Application for a non-material amendment following a grant of planning permission.

EXTEND GARAGE approx 2.260m just one half brick
short of house wall to form extra work shop
area for tools, garden mower bikes etc

1269/01/02

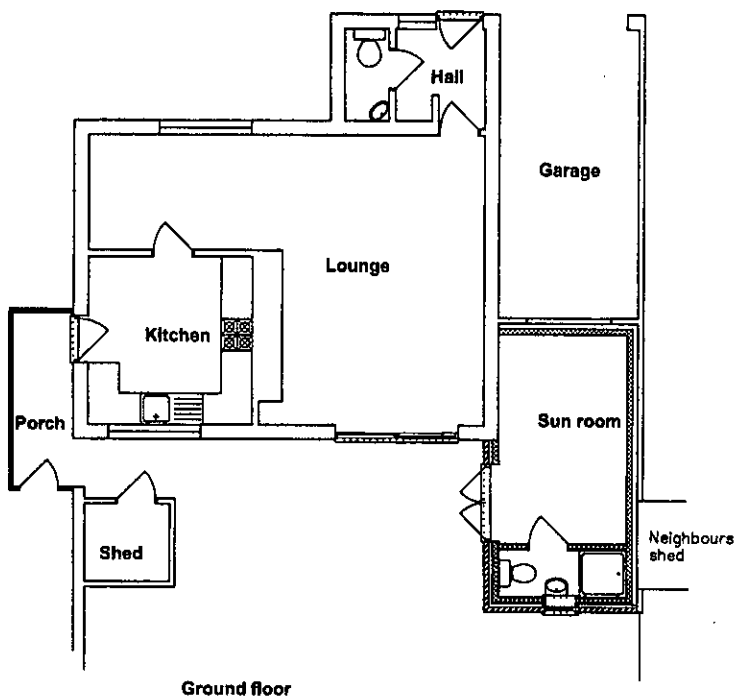
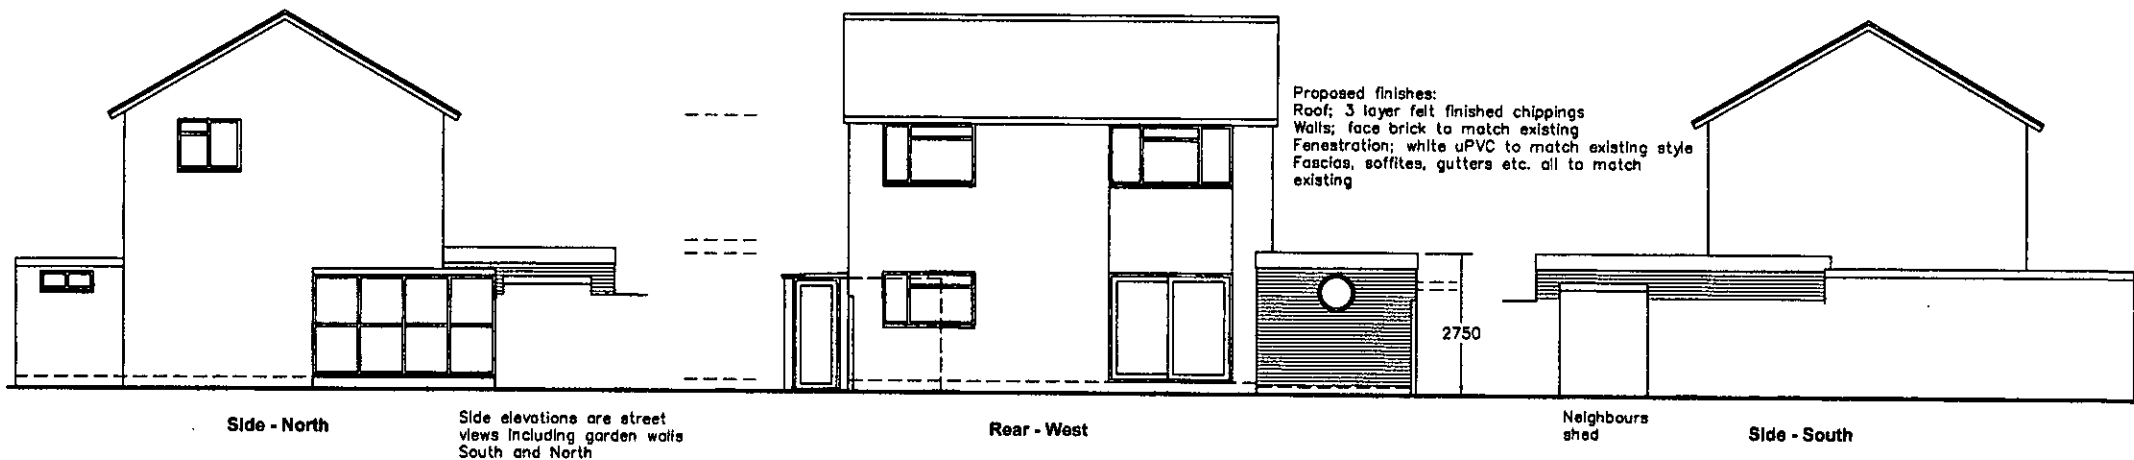
build ^{half brick} wall across width ^{2.680m} in cooperation P.V.C patio
door / french door ~~2.680m~~
raise garden wall to height of existing garage 2.260 length
half brick
timber roof joists ^{plywood} boardings. 3 layers felt.
extend plastic gutter

NO NEED FOR ACCOMADATION EXTENSION AS SON
HAS MOVED AWAY MORE USE AS WORKSHOP
tool STORE
